TfNSW reference: REN25/00088/002

**SSD-77238990, South Coree Battery Energy Storage System, 384 Broockmanns Road, Finley 2713;
Response to Environmental Impact Statement**

Transport for NSW (TfNSW) is responding to South Coree Battery Energy Storage System (BESS), exhibited from 7 November 2025 and referred via the Major Projects Portal.

TfNSW has reviewed the Environmental Impact Statement (EIS) prepared by NGH Pty Ltd, dated 22 October 2025, and Traffic Impact Assessment (TIA) prepared by Amber Organisation, dated 10 October 2025, as key documents for preparing this response.

Figure A-1 Concept intersection design for the Riverina Highway and Canalla/Martenellis Roads

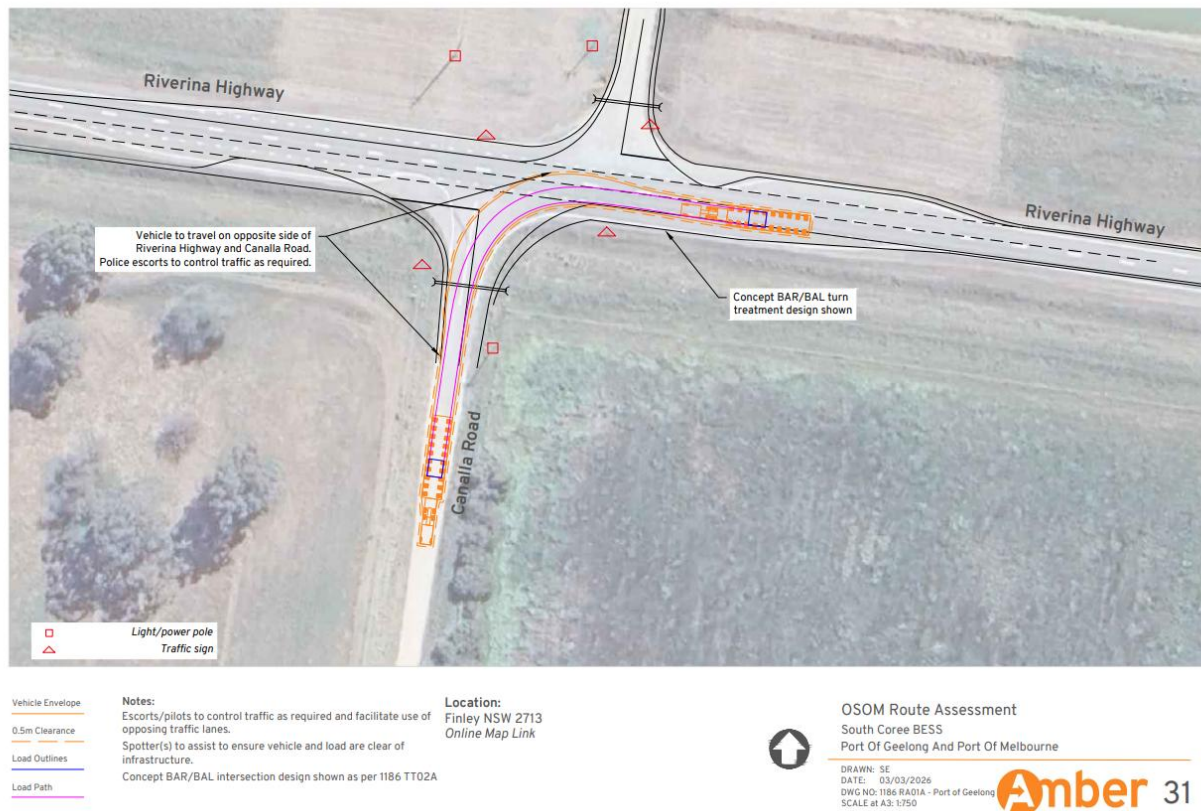
Swept path assessments have not been completed for the design heavy vehicle (i.e. 26 metre B-double, as indicated in Section 4.21 of the TIA) at impacted State Road intersections, particularly the Riverina Highway/Canalla Road intersection, as Canalla Road is not an approved B-double access road.

Swept paths for the design vehicle are shown to indicate that there is no conflict with concurrent left-in/ left-out and right-in/right-out movements. Swept paths are to be produced in accordance with *Austrroads Design Vehicles and Turning Path Templates*.

The traffic assessment assumptions and turn warrants assessment must be updated within the revised TIA. The strategic concept designs for the intersection of Riverina Highway/Canalla Road will need to be revised if a higher-order intersection treatment, beyond what is currently proposed (BAR/BAL), is warranted based on the revised turn-warrant assessment or provide alternative mitigation measures (i.e shuttle bus etc) to ensure that the project construction traffic volumes for the peak of construction can comply with the BAR/BAL intersection treatment.

The Basic Right Turn treatment on Riverina Highway, which facilitates the right turn into Canalla Road, does not comply with Austroads. The increased traffic and proposed design vehicles will exacerbate the current safety issues with the non-compliant BAR. Strategic concept designs will be required to be submitted that demonstrate the scope of the upgrades necessary to the existing BAR to achieve compliance with Austroads and TfNSW requirements. The strategic concept designs will need to address the following specific non-compliances with the existing BAR:

- i) BAR does not meet the minimum requirement for the situation whereby a road user is not allowed to enter a dedicated left turn lane to pass / navigate around a stored vehicle turning right into the side road.

The proponent must design a compliant BAR intersection treatment and line mark the edge line at a constant 3.5m from the centreline to provide a widened shoulder to satisfy the requirement of a BAR (refer to *Austroads Guide to Road Design Part 4A*, Section 7). The re-design will impact the existing treatments to Marantellis/Riverina Highway. The proponent in their re-design will therefore, need to consider what an appropriate BAR treatment is for both the Canalla and Marantellis Road intersections with the Riverina Highway and ensure both roads have compliant treatments. Consideration to upgrading the intersection with opposing CHRs should be given by the proponent due to the unconventional existing intersection design.

- ii) A hold line is to be included set back from the through edge line to hold side road traffic free of the widened shoulder to ensure the BAR intersection treatment will operate as intended. Austroads Figure 7.1 demonstrates requirements for a compliant hold line setback. The setback should take into consideration the unconventional design of the road.

- iii) **Bus bays:** The proponent is to demonstrate a safe and conforming solution for the intersection upgrades that take into consideration the existing bus bays. The proponent is to be aware that if modifications to the bus bays are required to achieve an optimal design, consultation will need to occur. Consideration of relocating the bus bays to allow for an improved, optimized design, should be given. There is potential for a rear end type crash when the bus bay is in use, as there appears to be insufficient offset between the intersection treatment and the bay. Line marking the edge line through at a constant offset should also be considered.

- iv) **Road Train width requirement:** The Riverina Highway is a gazetted Road Train route (i.e B-triples) at this location. The strategic concept designs are to demonstrate an increase of the width of the AUL(s) and BAR for the Canalla Road/Riverina Highway intersection to accommodate the road train heavy vehicles passing the turning project traffic. See advisory note for references to Austroads.
